Our Ref: Y/95/20/DOC

Town & Country Planning Act 1990 (as amended)
Town and Country Planning (Development Management Procedure) (England) Order 2015
Approval of details reserved by condition imposed under ref Y/13/18/PL relating to Condition Nos 16 -
refuse & recycling bins and 19 - parking.
Street Buildings North End Road Yapton BN18 0DT

Scale 1:500 @A1	Date SEP 2019	Designed MS
Drawn MS	Checked SG	Approved LH
Job No 18-343	Drawing No 18-343/100	Rev C

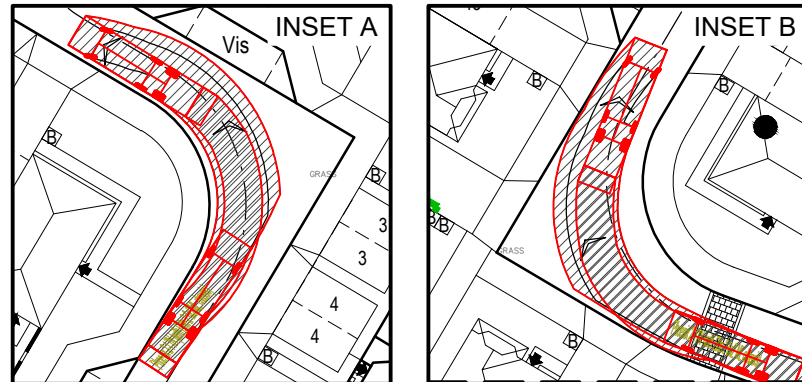
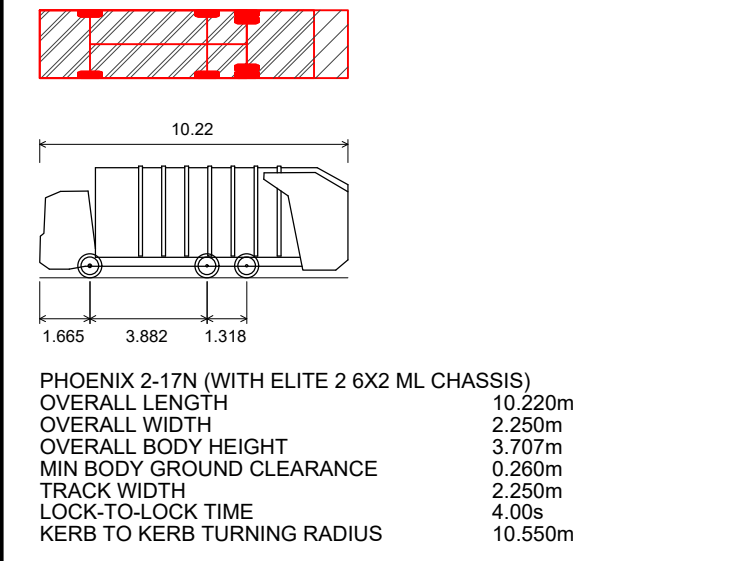
The submitted details in respect of bin storage namely drawing 20 Rev F "Refuse Plan" which specifies that bins will either be stored in the shared bin stores (the details of which were approved by Y/39/20/RES) or in rear gardens with frontage collection points is acceptable. In addition, WSCC Highways have appraised drawing 18-343/100 Rev C "Refuse Vehicle Swept Path Analysis" and raise no concerns.
